**Re: Lot 17 Block 7 SAD 228  
Volcano Cliffs Subdivision Unit 18  
6527 Papagayo Rd. NW  
Grading and Drainage Plan  
Engineers Stamp Date 3/2/2020 (D10D003L17)  
Pad Certification Date 7/31/2020  
CO Certification Date 12/19/2022**

Based on the Certification received 12/24/2022, the site cannot be accepted for release of Certificate of Occupancy by Hydrology until the following comments are addressed.

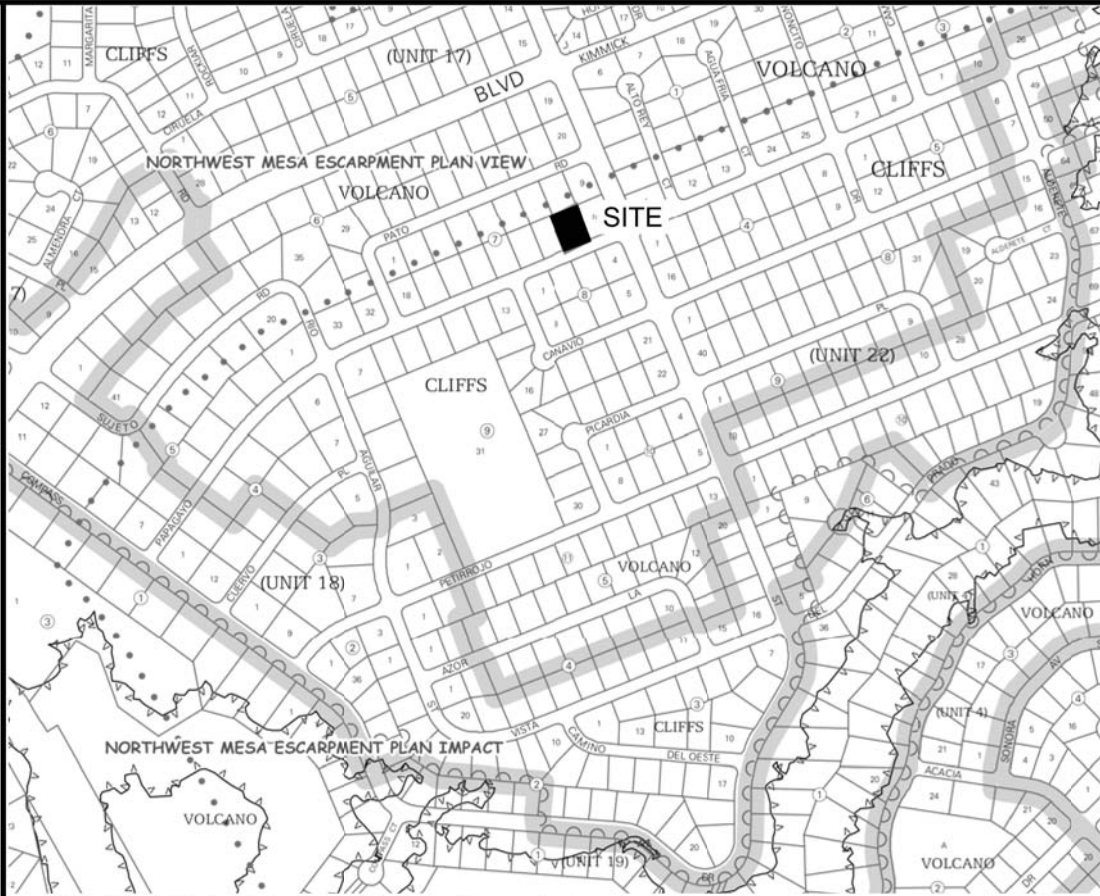
- All ponding areas and swales need to have gravel in place.
